**Application by EDF Energy (Thermal Generation) Limited for the West Burton C Power Station**  
**The Examining Authority's Written Questions and requests for information (ExQ1)**  
**Issued on 6 November 2019**

**Responses are due by Deadline 2: 6 December 2019**

Drawing Number 60527350/WBC/ES/FIGURE 14.1	Rev 0
---	----------

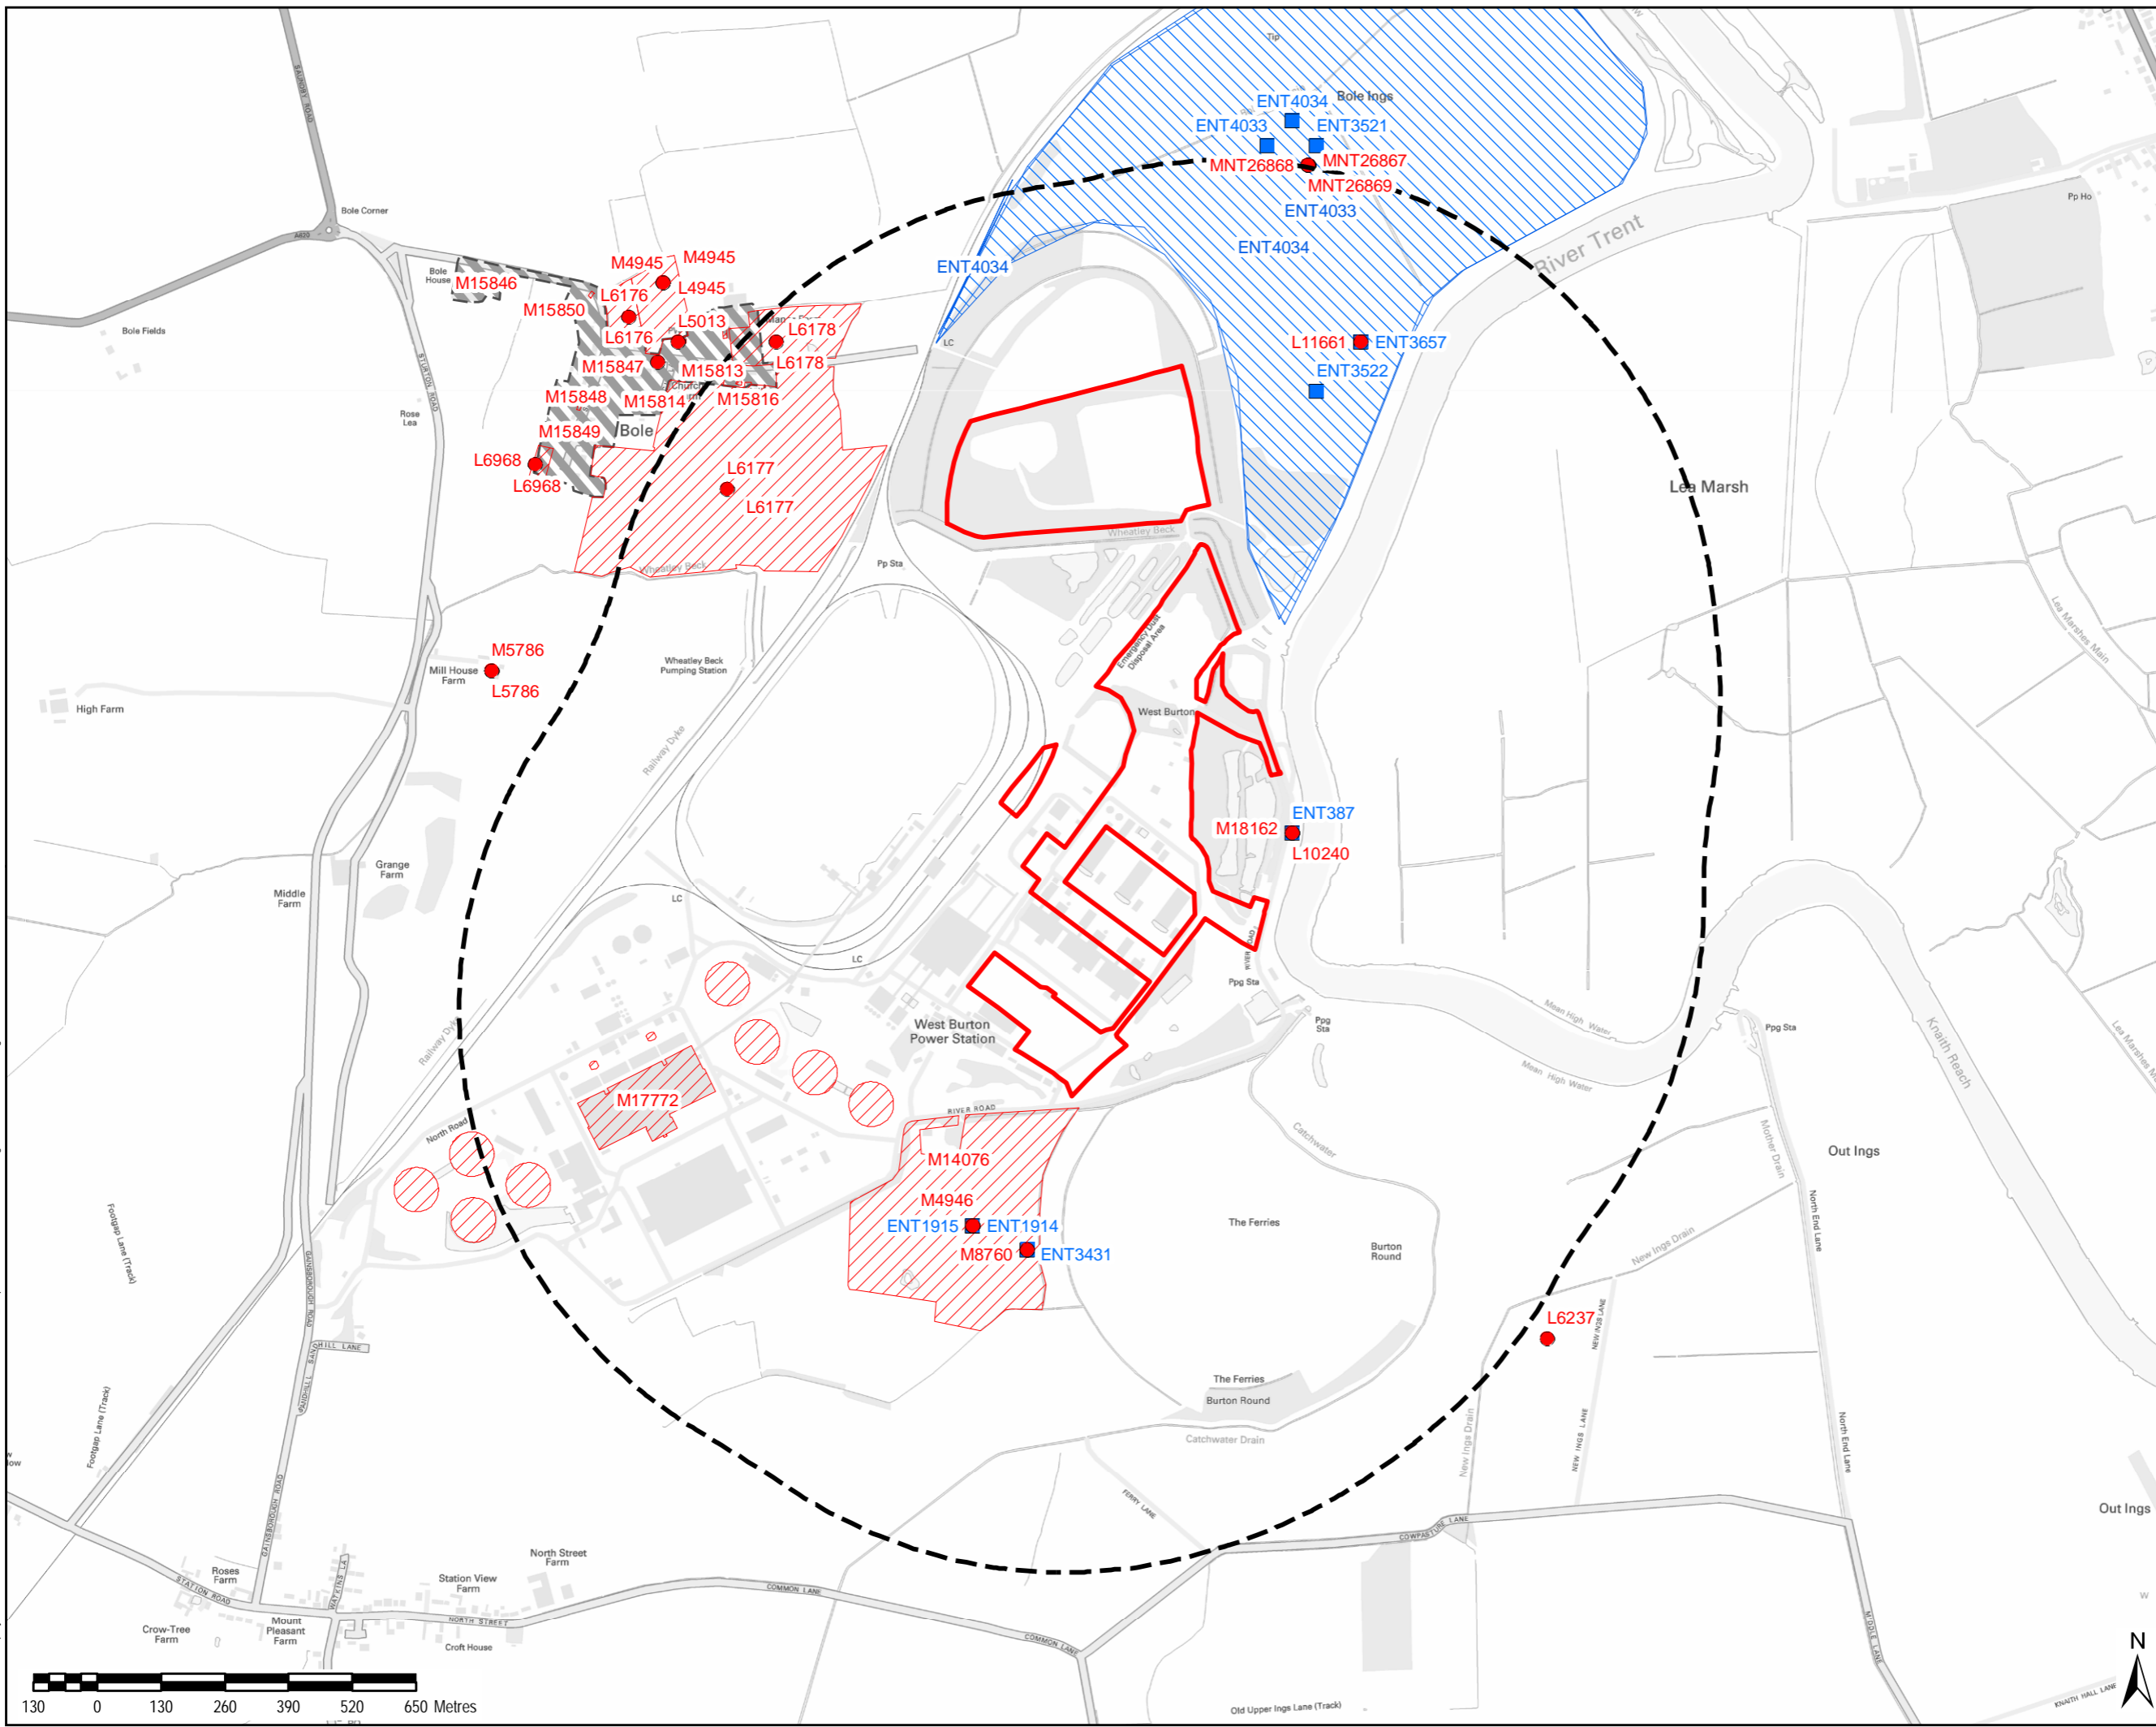
<b>ExQ1</b>	<b>Question to:</b>	<b>Question:</b>
<b>6.</b>	<b>Historic Environment</b>	
Q6.1	The Applicant	In ES Chapter 14 [APP-043] why do designated heritage assets have a search area with a 3km and 5km radius from the centre of the site but non-designated heritage assets have a search area with a 1km radius?
Q6.2	The Applicant	The search area for non-designated heritage assets as shown on ES Figure 14.1 [APP-127] does not appear to be circular. What is the reason for this if, as indicated, it has a 1km radius from the centre of the site?
Q6.3	Historic England, Bassetlaw District Council and West Lindsey District Council	Are Historic England, Bassetlaw District Council and West Lindsey District Council satisfied with the extent of the search areas for designated and non-designated heritage assets as set out in ES Chapter 14 [APP-043] and as shown on ES Figure 14.1 [APP-127] and ES Figure 14.2 [APP-128]?

Drawing file: EN010088 / EN010088-000347-5.2 - WBC - ES Figure 16.2 - Short List of Development Considered for Cumulative Impact Assessment.pdf

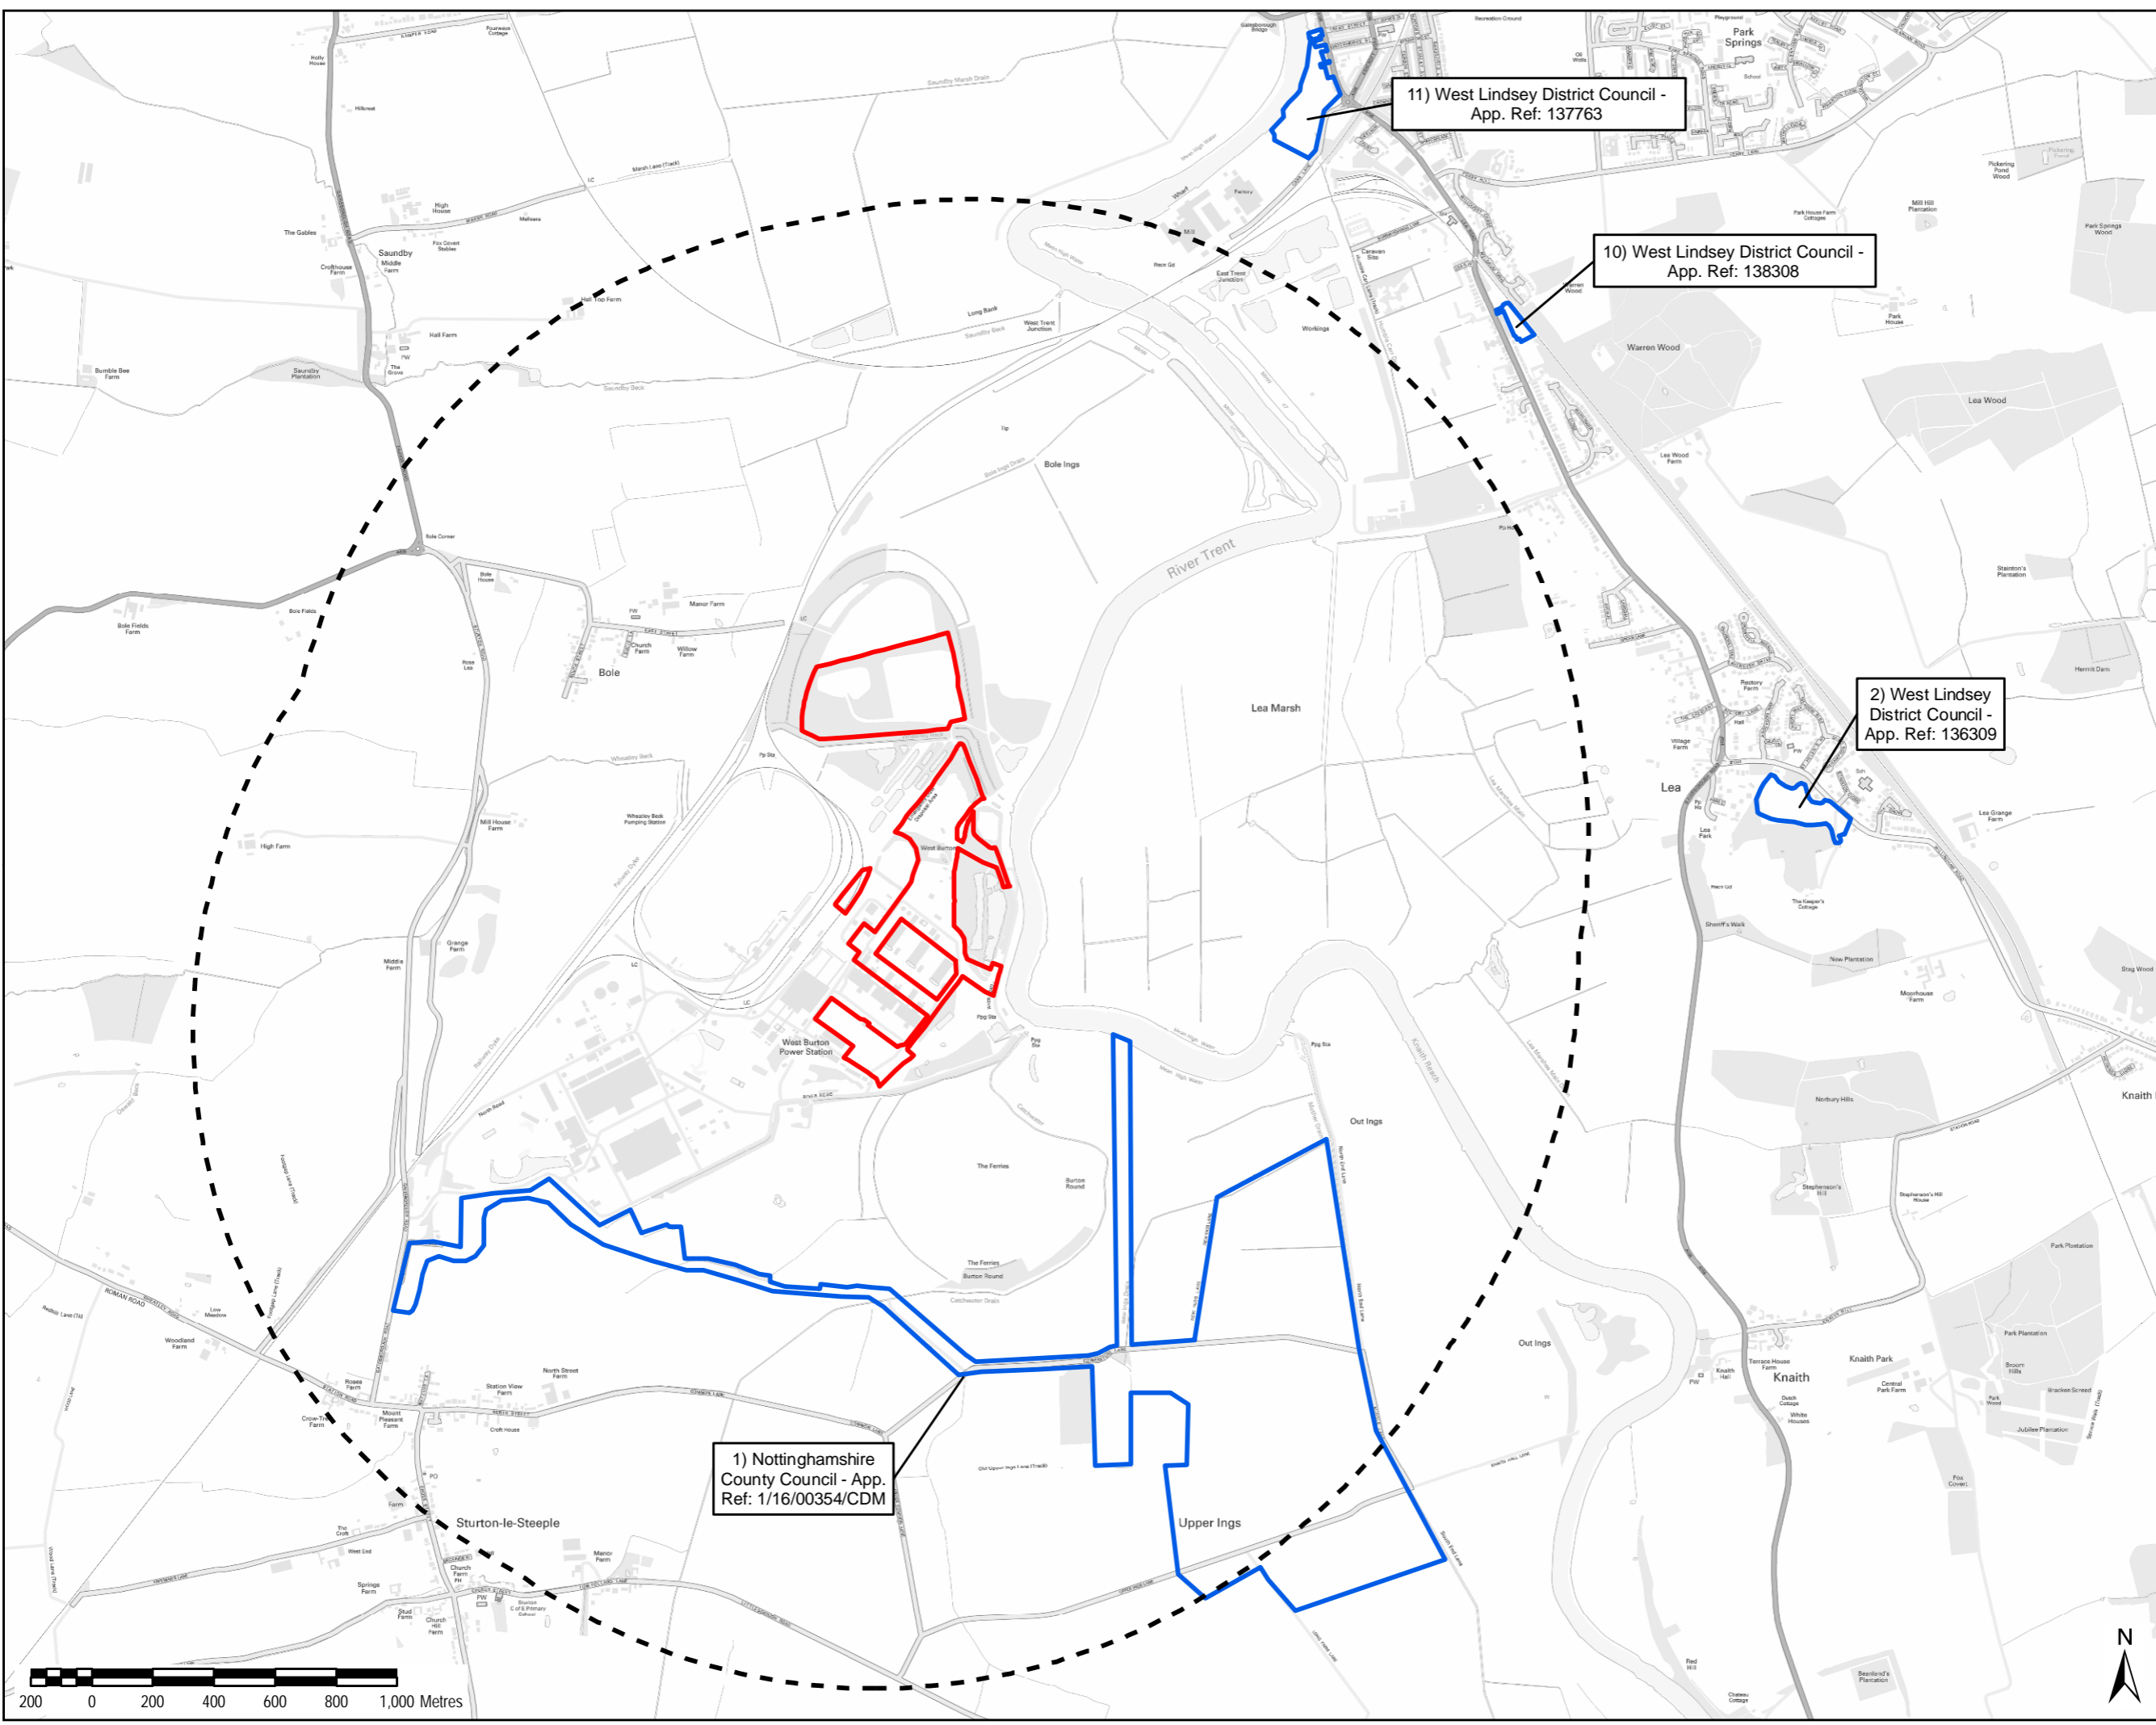
<b>ExQ1</b>	<b>Question to:</b>	<b>Question:</b>
		conclusions in the ES?
Q1.8	The Applicant, Bassetlaw District Council and West Lindsey District Council	Has the shortlist of major projects in respect of the assessment of cumulative effects identified in Table 16-5 of ES Chapter 16 [APP-045] and on ES Figure 16.2 [APP-131] been agreed with/by the relevant local authorities?
Q1.9	The Applicant	Is there any further information available relating to plans for the closure of West Burton A which might affect the ES for the Proposed Development?
Q1.10	The Applicant	Does the recent closure of Cottam Power Station have any bearing on any aspect of the ES for the Proposed Development?
Q1.11	The Applicant	Do the indicative elevational drawings [APP-023 and APP-024] reflect that the Proposed Development may sit at up to 14m above ground level and if not, should they?
Q1.12	The Applicant	Does the Applicant intend to submit a s106 agreement in relation to any part of the Proposed Development?
